RE: My Little World, 303 Old Coors, Rd. Building Permit # BP-2021-18764, TCL # SI-2021-00991

I have reviewed your comments provided on July 05, 2021 and have provided responses to your comments below. The revised drawing AS103 and associated documentation is attached for your review.

AS103

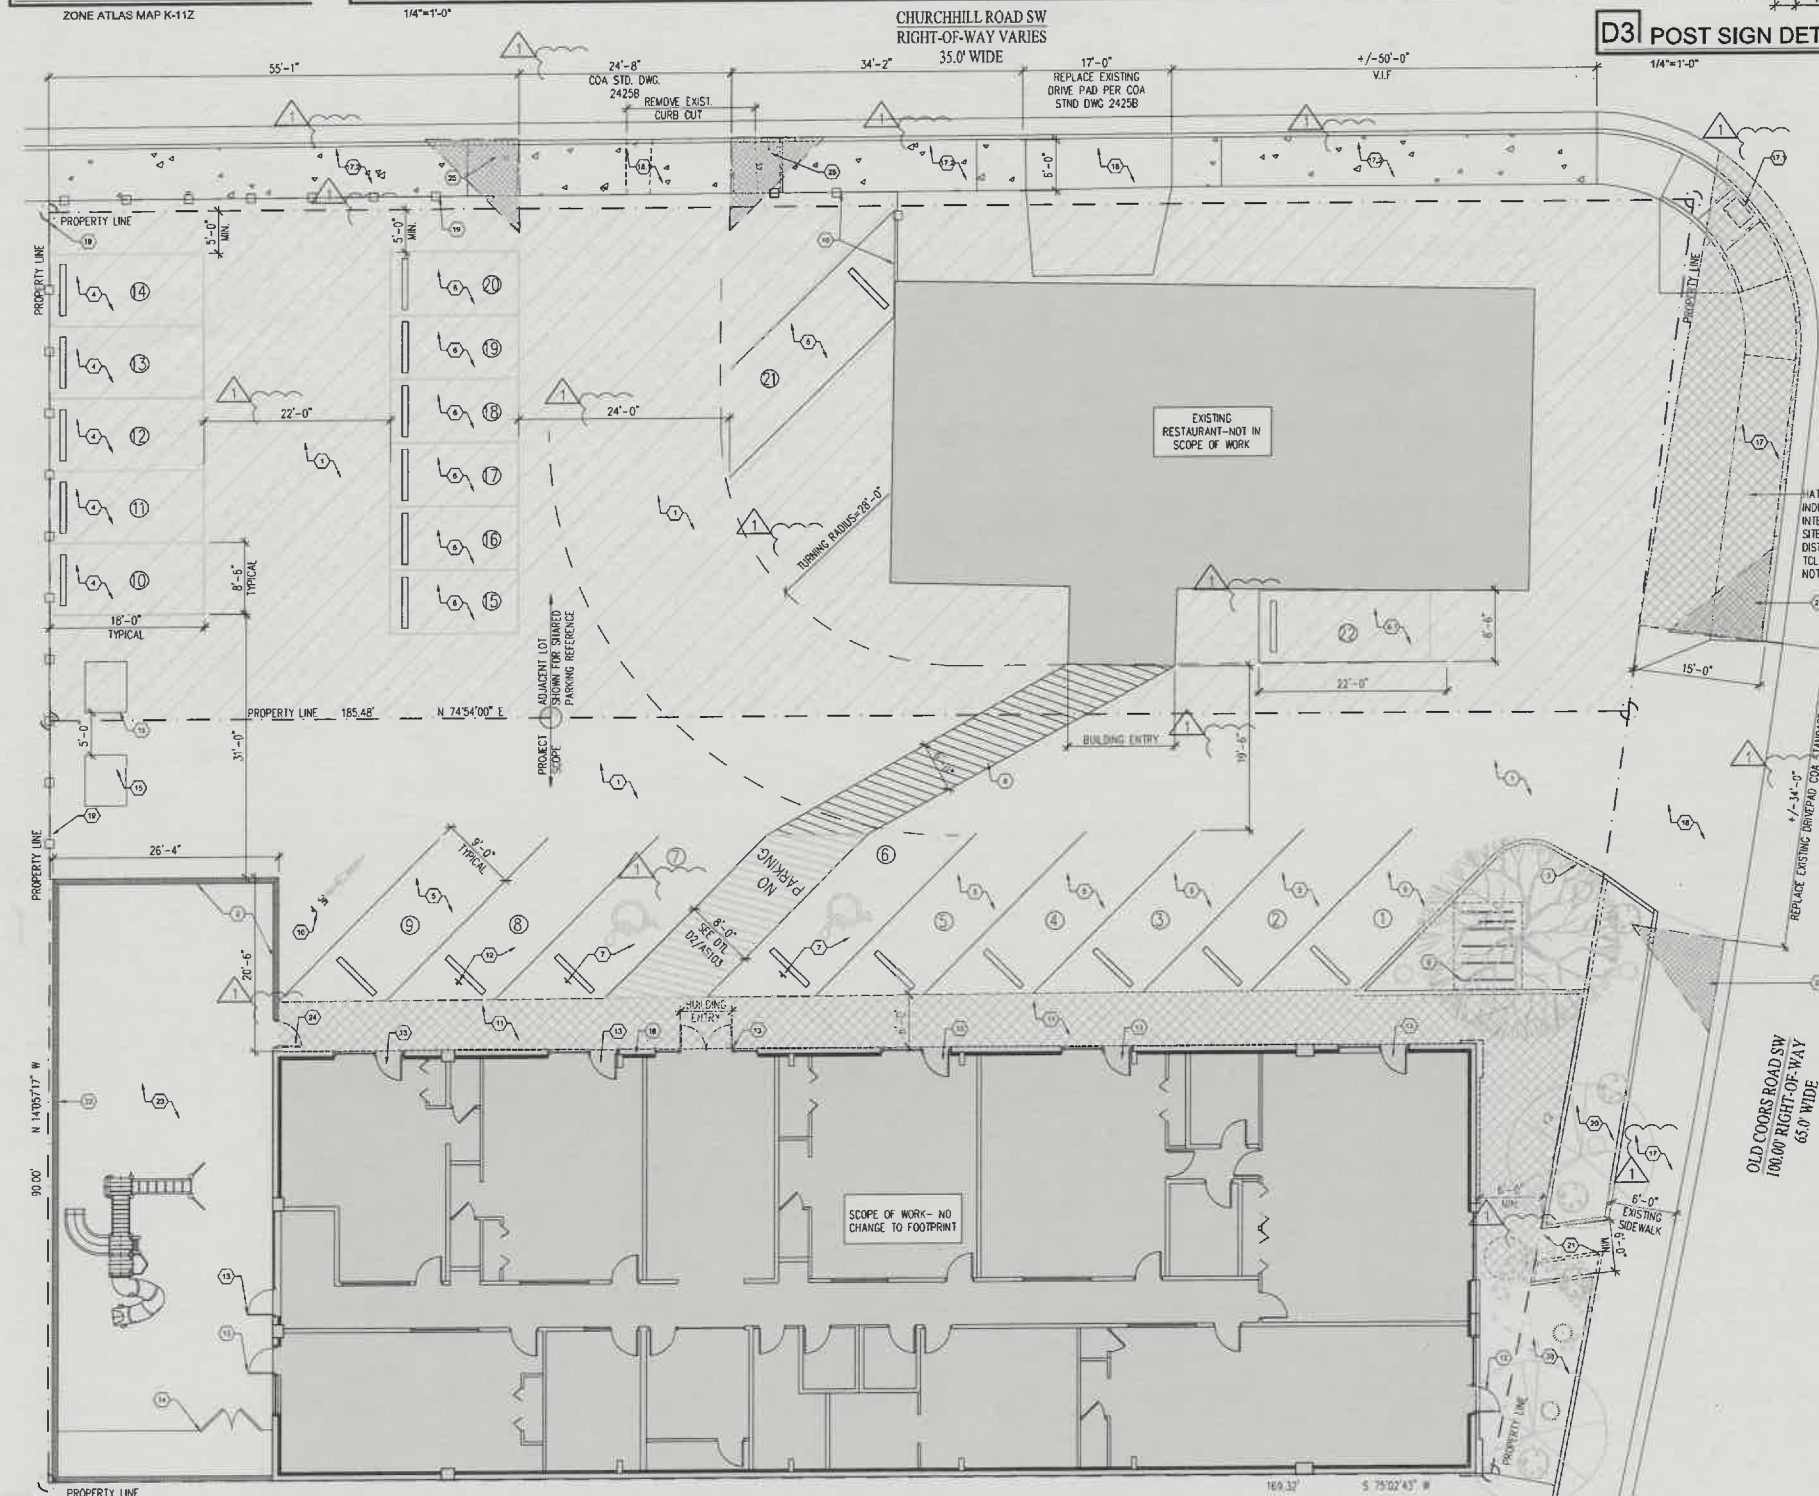
- The proposed diagonal parking stalls are encroaching into the drive aisle and driveway path. This is cause a traffic safety concern since maneuvering out of the stall will occur on COA ROW. This type of backing out onto COA ROW is not acceptable. Please address this traffic concern. The FD needs 20'-0" for their vehicles and the aisle is only 12'-0" in width. (Obtain FD concurrence with proposed drive aisle widths thru out site).

11. Old Coors Drive is a minor arterial. The existing Driveway is +/-34'-0". There are already problems with the parking stall layout not matching the existing width and the FD requirements for the drive aisle width of 12'-0". Please address ingress movement issue on southbound Old Coors Drive.

15. The ADA accessible spaces must include an access aisle. Van accessible aisles should be 8'-0" width all others 5'-0" wide. It appears from the plan that it is 6'-0" wide. Please clarify.

16. ADA curb ramps must be updated to current standards and have truncated domes installed. Verify the existing ramp at the corner of Church Hill Road/ Old Coors drive is current ADA with detectable warning Surfaces.

22. (24) A 5'-0" keyway is required for dead-end parking aisles.  
**Response: A 5 foot key way is indicated on the drawing.**
23. (25) Per the IDO a 6'-0" ADA accessible pedestrian pathway is required from the public sidewalk to the building entrances. Please clearly show this and provide details.

24. (26) Per DPM a 6'-0" wide ADA accessible pedestrian pathway is required from the ADA parking stall access aisle to the building entrances. Please clearly show this pathway and provide details. You show pathway but don't include the type of surface that is being proposed.

**Response: Spaces have been moved to northwest side of parking area. See revised plan. A copy of Permit #21-006813 approving the access has been included for your use.**

**Response: Offending parking spaces have been relocated to resolve traffic concerns. See revised plan.**
12. Please list the width and length for all existing and proposed parking spaces. Some dimensions are not shown.

**Response: Keyed note #7 references the HC parking space which indicates the 8'-0" wide van access aisle. The 6'-0" dimension is clearly shown as the access aisle connecting the two buildings and providing required pathway between restaurant and its associated HC space. A Dimension has been added to the plan for clarity.**

**Response: The existing ramp is current ADA compliant per COA Standard Drawing 2441, but landing does not. Drawings have been revised to include note to replace landing. The area does include detectable warnings. Notes to this effect have been added to the drawing.**

**Response: The required path is shown on the drawing. I have included a new hatch pattern to clarify for you. Keyed notes provide width and have been updated to include language related to slopes.**

**Response: All existing parking lot is asphalt and is to remain. Pathway surface to be existing asphalt. A hatch pattern has been added to the drawing for clarity.**
